Town & Country Planning Act 1990 (as amended)
Town and Country Planning (Development Management Procedure) (England) Order 2015
Approval of details reserved by condition imposed under ref LU/234/16/RES relating to Condition No 7
- acoustic barrier
Fitzalan Link Road Littlehampton

Arun District Council have decided to **APPROVE details reserved by this condition**

The following information submitted regarding Condition 7 imposed on reserved matters approval LU/234/16/RES: relating to the materials for the 3.5 metre high acoustic barrier is approved and the condition is hereby discharged.

Drawing Title:
PHFL-WYG-S278-LP-FL4 Rev. V - Location Plan
(Proposed S38/S278 Highway Works)
Fitzalan Link (Sheet 1 of 2)

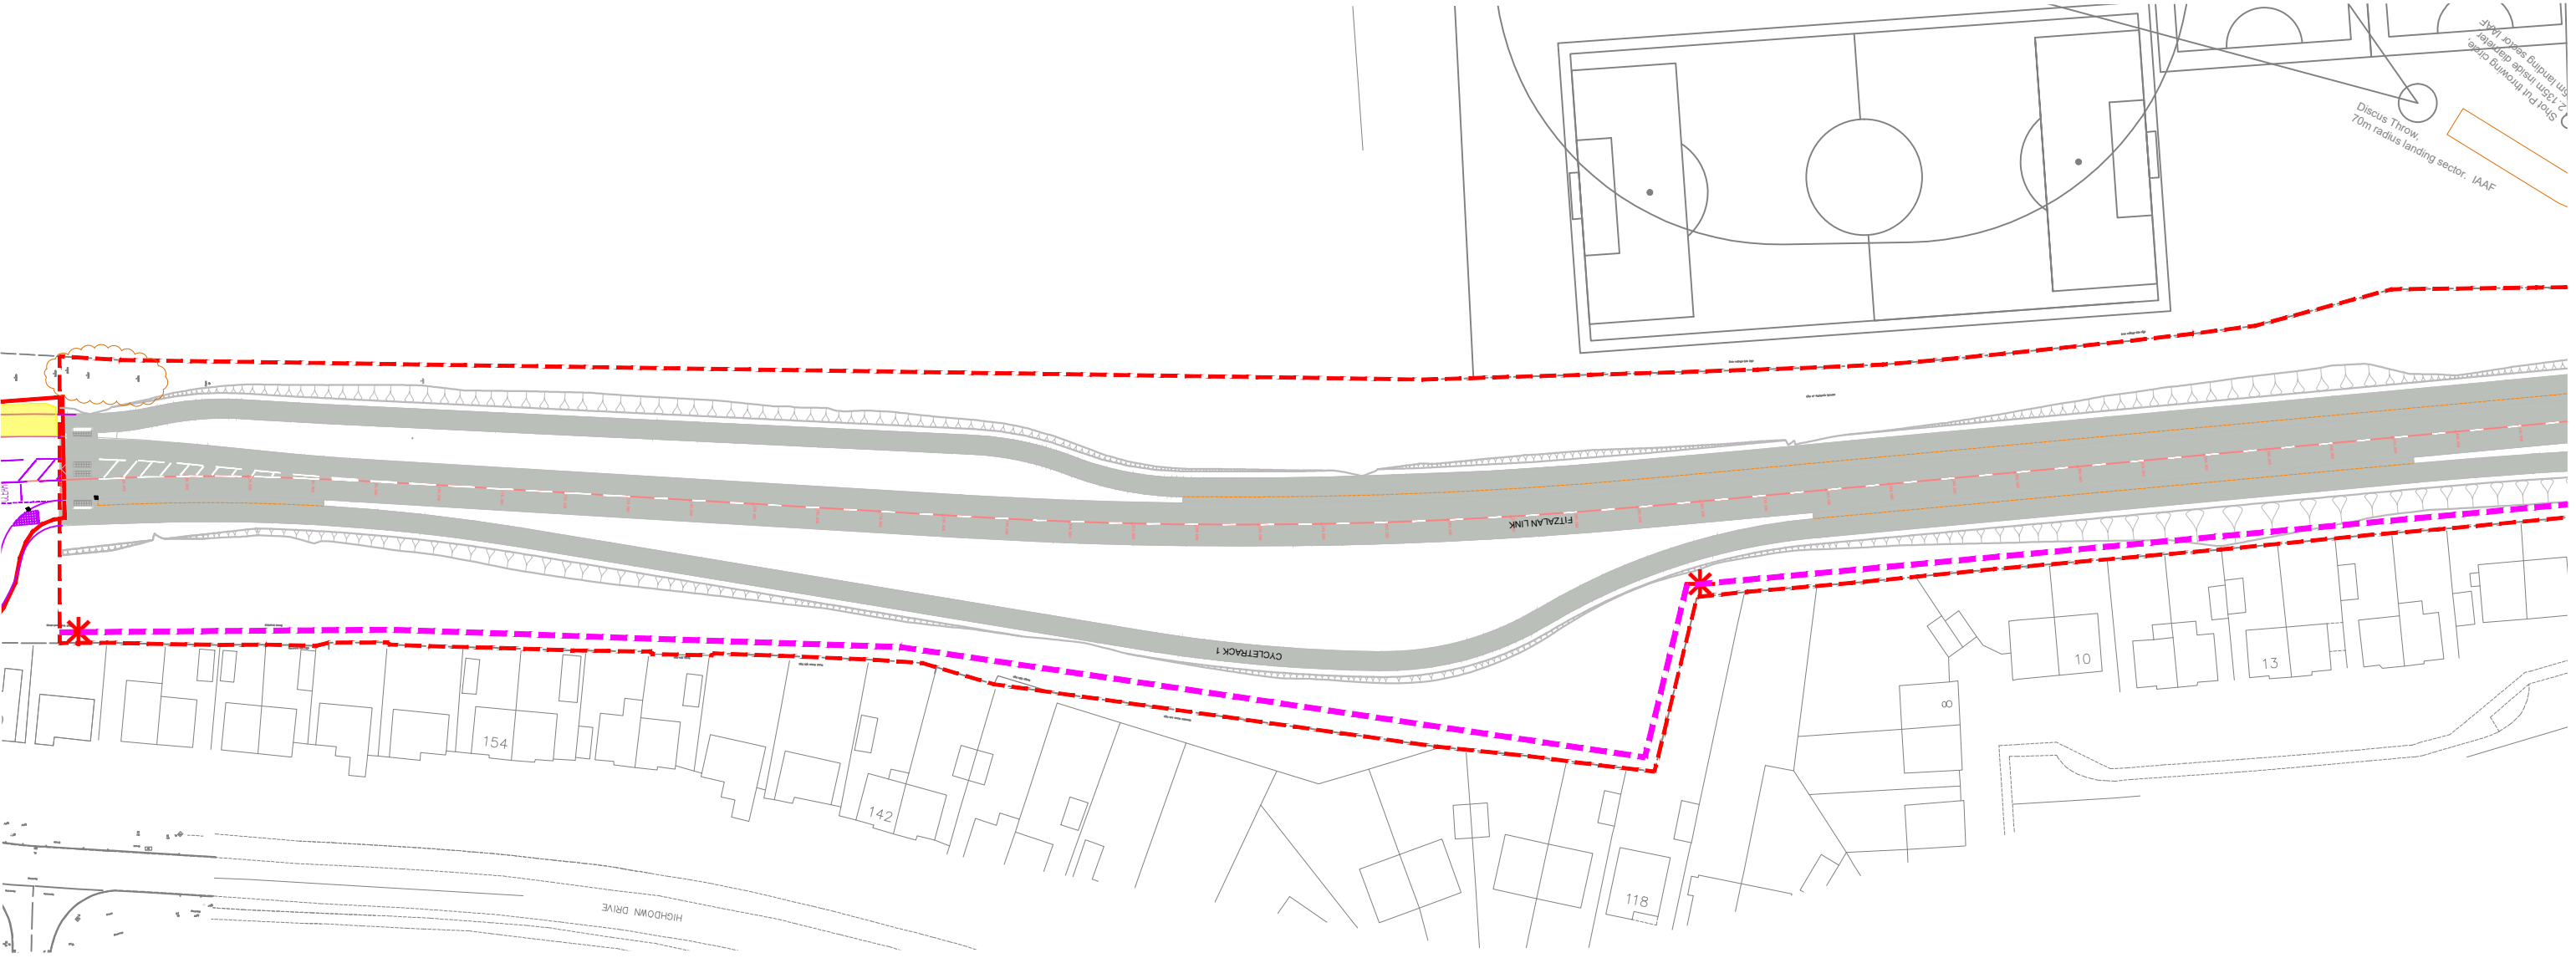
The Local Planning Authority attempted to secure improvements to the acoustic fence by it being constructed on top of the landscaped bund, where there are landscaped bunds proposed. If the bund is 2.0 metres high for example, 1.5 metre high acoustic fence could be constructed on top of the bund, so as to provide a total height of 3.5 metres.

It is understood that this is not possible because the road is not creating a landscaping bund as the whole road is elevated between 100mm and 400mm above exist ground level, with a small slope to the back fences. Therefore there is no option to lower the height of the fence.
